Application No: AL/35/21/DOC
Site Address: Norton Farm House Norton Lane Norton PO20 3NH
Description of works: Approval of details reserved by condition imposed on AL/34/20/PL relating to condition 5-site plan showing details of hard landscaping.

Thank you for your internet representation made on 7th May 2021 which has been recorded as an objection with the comments as follows:

DRAWING TITLE
EXTERNAL WORKS

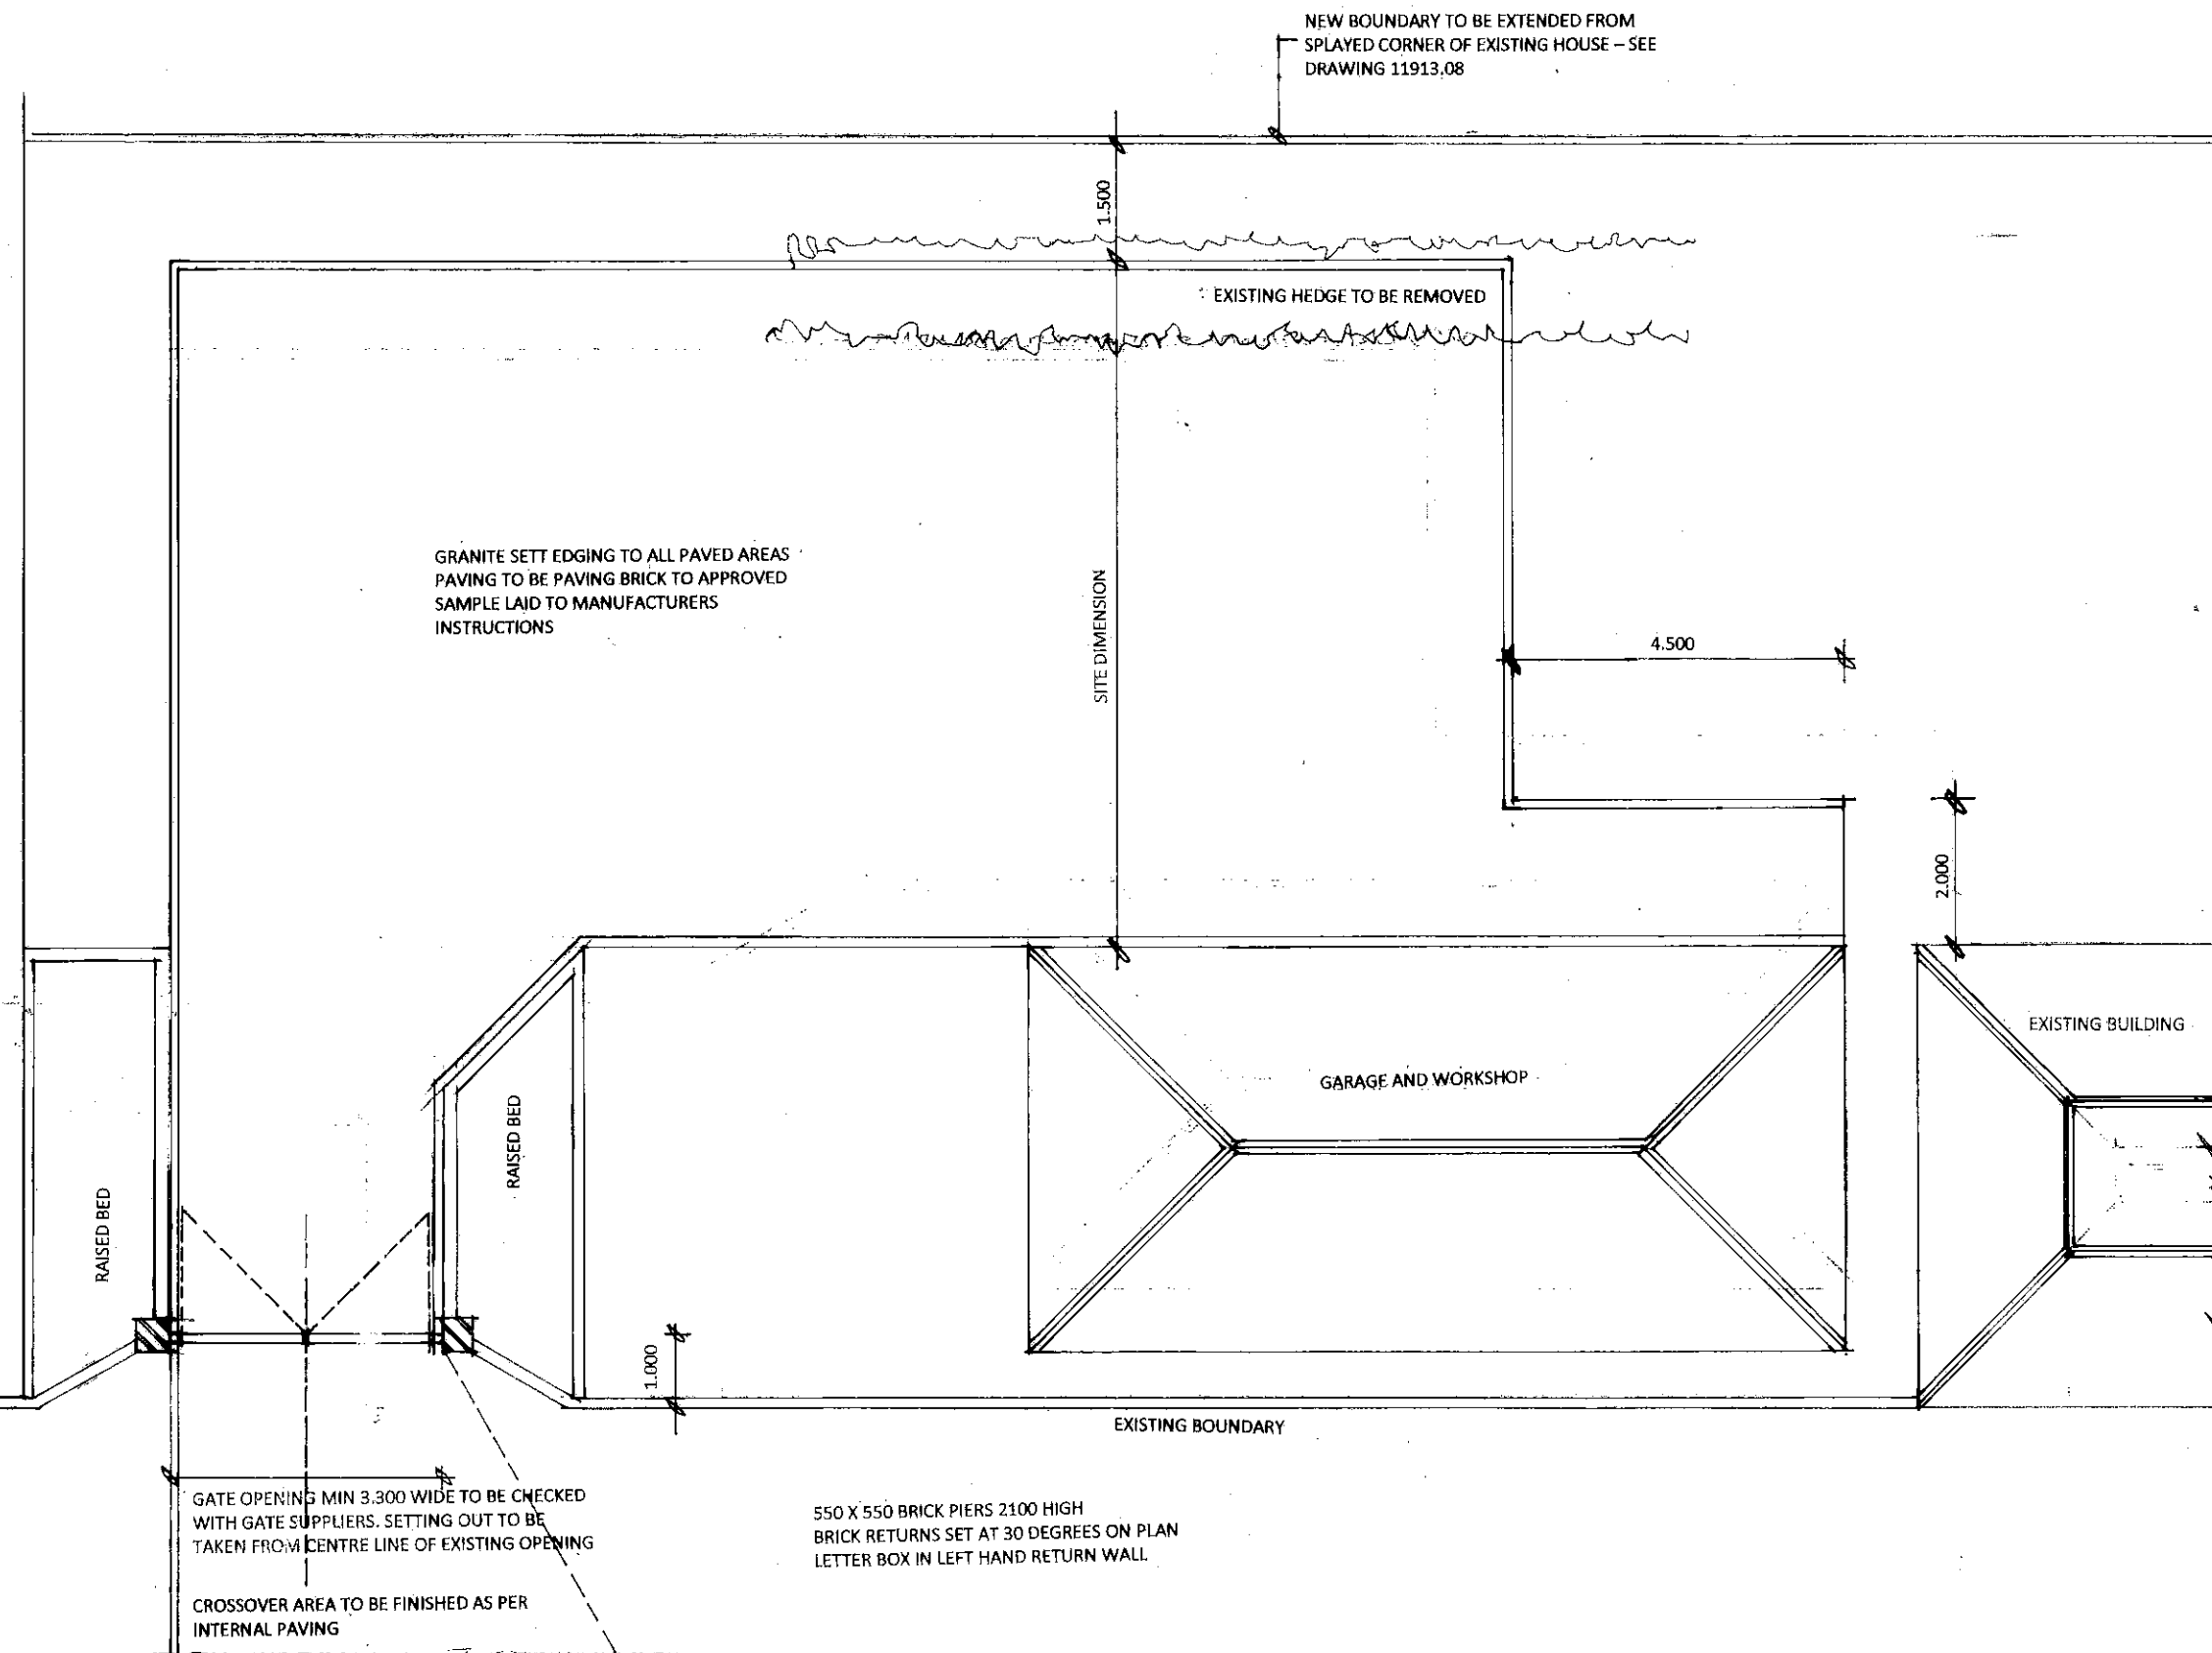
There are a number of issues of principle, planning breach and potential precedent with this application. It essentially seeks to discharge the landscaping condition applied to the approval of applications AL/34/20/PL and AL/35/20/PL. However, it seeks to do so retrospectively as the majority of the work is already completed.

The site is within the curtilage of a Listed Building and within a Conservation Area. Approvals AL/34/20/PL and AL/35/20/PL granted permission for the construction of an oak framed outbuilding with larch lap cladding for use as a garage. What has been constructed on site is a brick building with a roof structure greater than the height of the adjacent buildings (not consistent with the approvals) and with a roof of a hipped nature rather than the gable ended nature approved. The above breaches of planning resulted in a Temporary Stop Notice being issued on 18th March 2021.

The building as constructed and its associated hard landscaping are not consistent with Aldingbourne Local Plan policies EH8 and EH9 and Arun District Council Local Plan policies HER DM1 and HER DM3.
